TfNSW Reference: SYD20/00390/07

Client Reference: SSD-10446

**FURTHER INFORMATION - ADVICE ON RTS - RESOURCE RECOVERY CENTRE - 275  
ADAMS ROAD, LUDDENHAM**

DRAWING TITLE  
**ROADWORKS PLAN  
SHEET 1 OF 2**

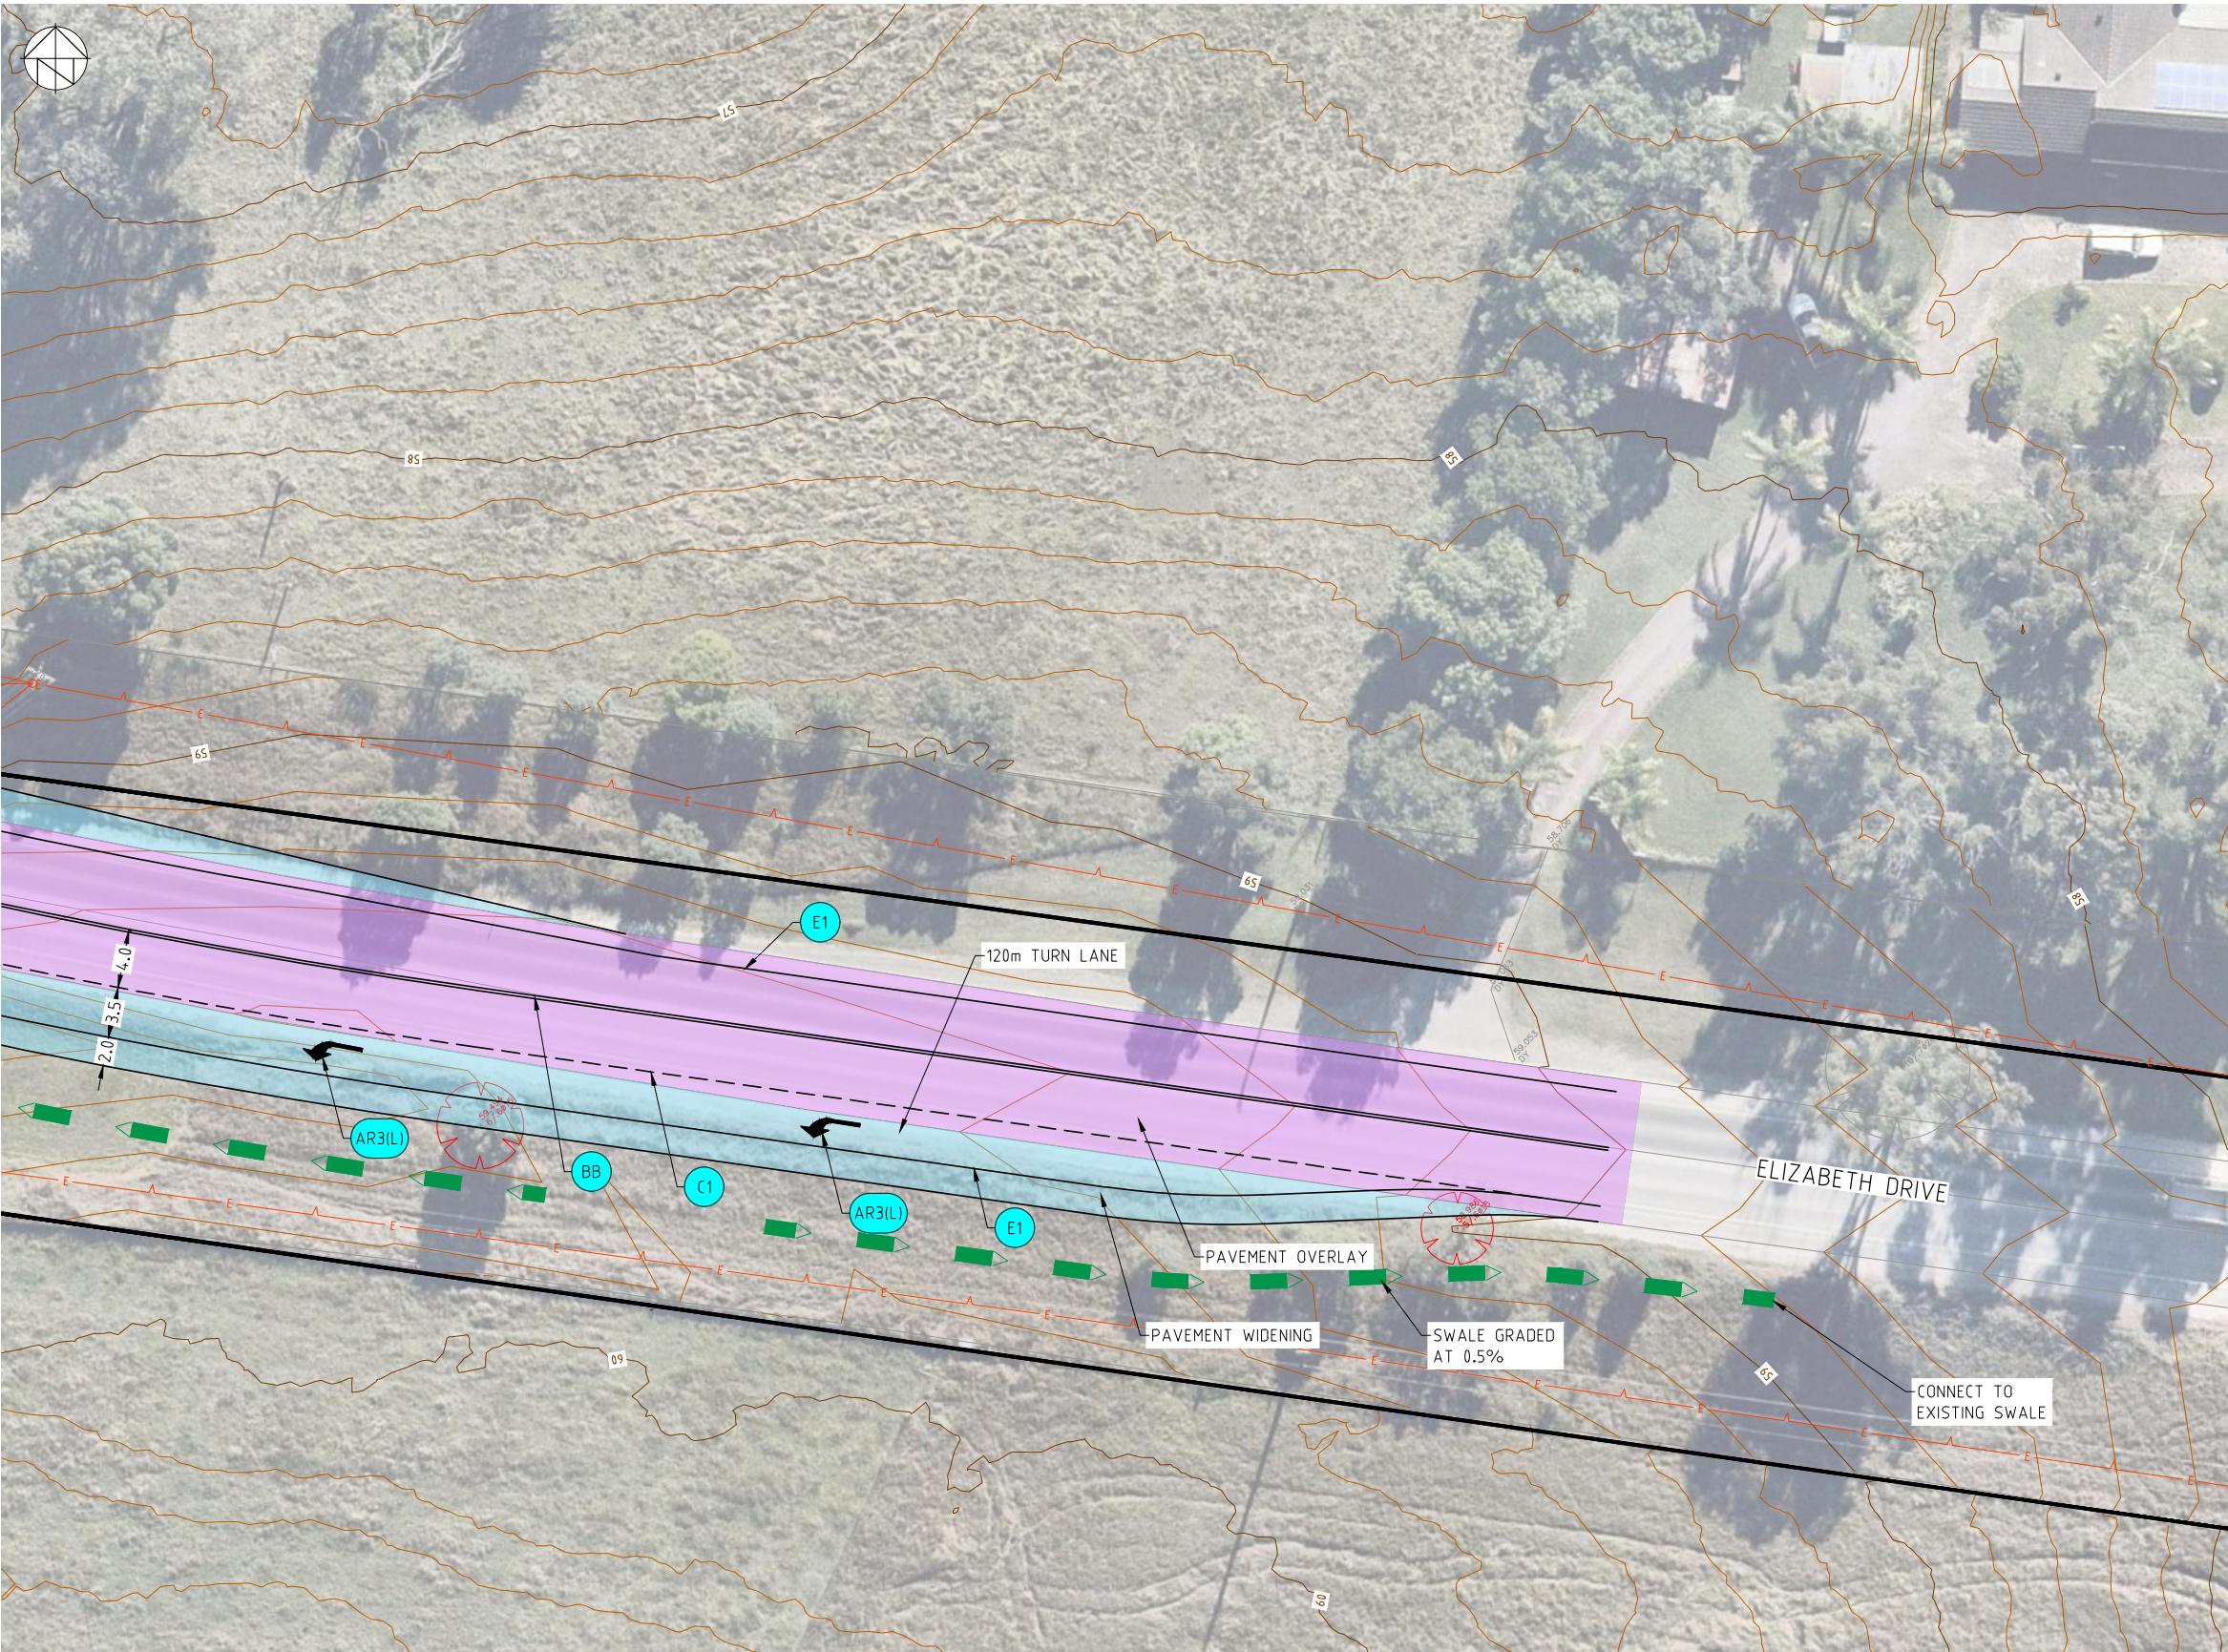
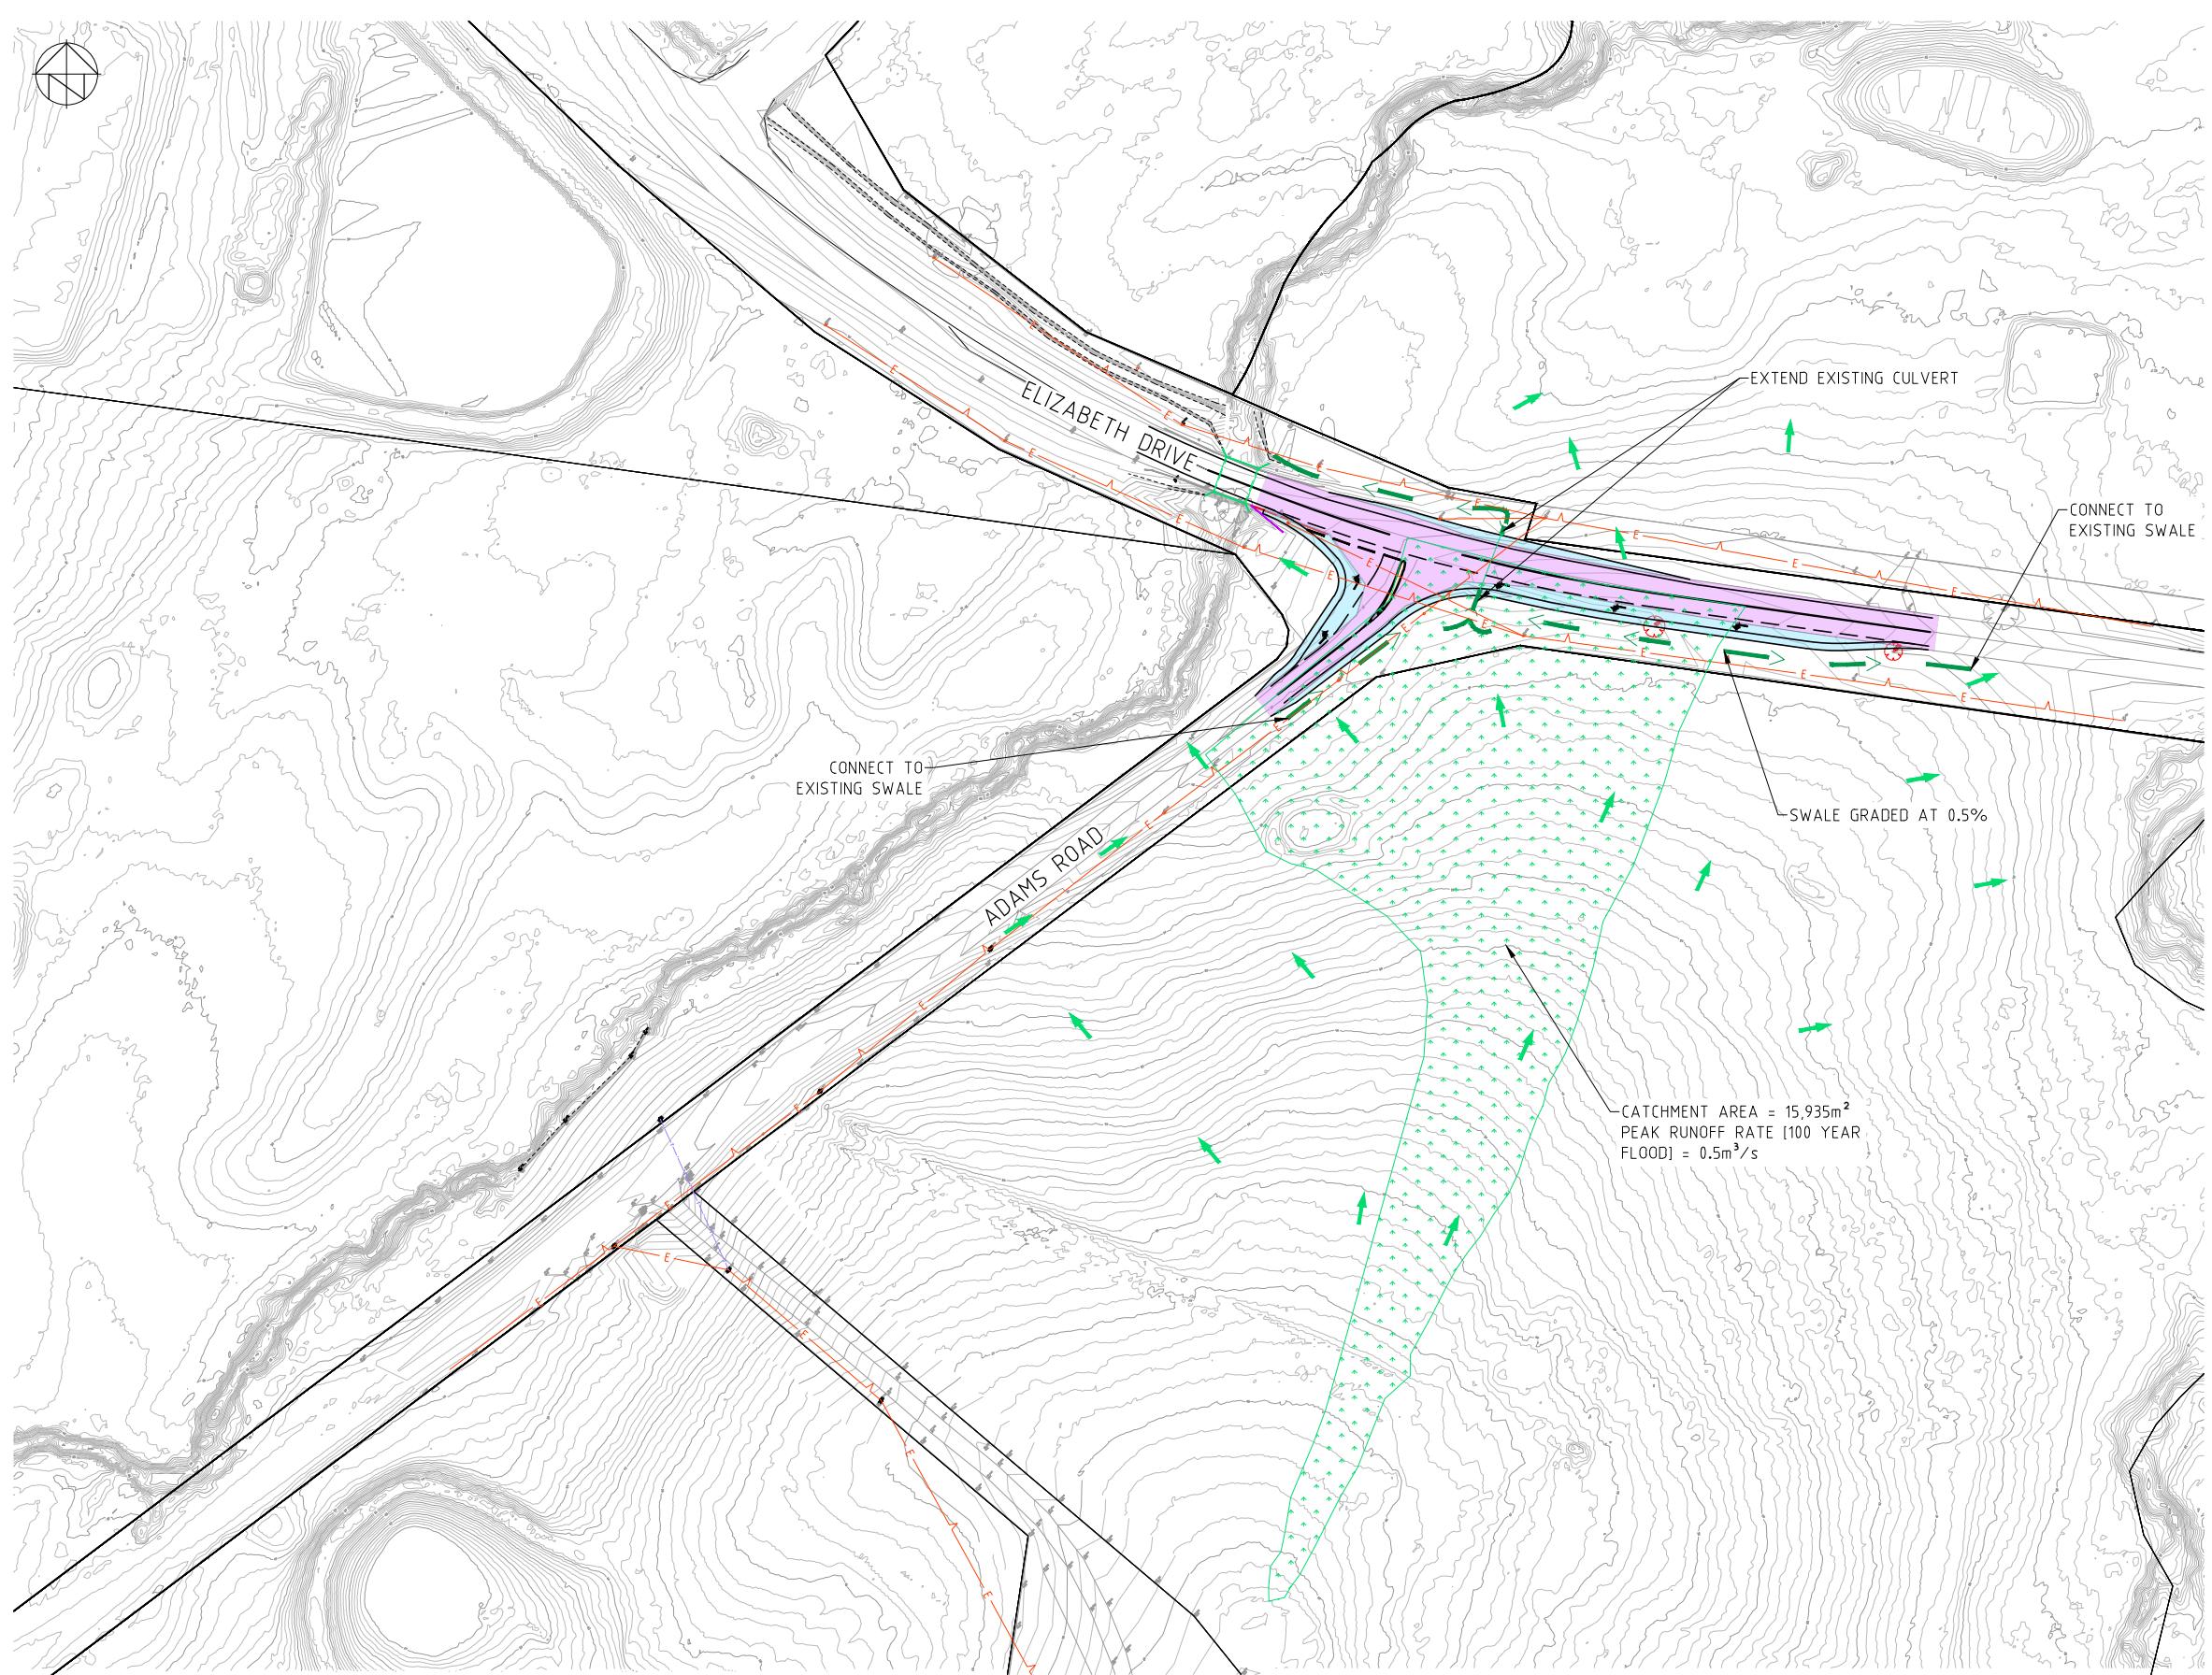
1. Prior to the issue of Occupancy Certificate, the developer must complete an interim upgrade of Elizabeth Drive and Adams Road intersection.

The proposed intersection upgrade shall be designed to meet TfNSW requirements, and endorsed by a suitably qualified practitioner. The design requirements shall be in accordance with AUSTRROADS and other Australian Codes of Practice. The certified copies of the civil design plans shall be submitted to TfNSW for consideration and approval prior to the release of the Construction Certificate by the Principal Certifying Authority and commencement of road works. Documents should be submitted to [Development.Sydney@rms.nsw.gov.au](mailto:Development.Sydney@rms.nsw.gov.au)

2. The developer shall prepare and implement a signage and linemarking plan for the intersection of Elizabeth Drive and Adams Road in consultation with TfNSW.

A signage of prohibiting right turn movement for Resource Recovery Centre vehicles from Elizabeth Drive into Adams should be installed.

3. Detailed design plans and hydraulic calculations of any changes to the stormwater drainage system associated with the proposed intersection upgrade are to be submitted to TfNSW for approval, prior to the commencement of any works. Documents should be submitted to [Development.Sydney@rms.nsw.gov.au](mailto:Development.Sydney@rms.nsw.gov.au)
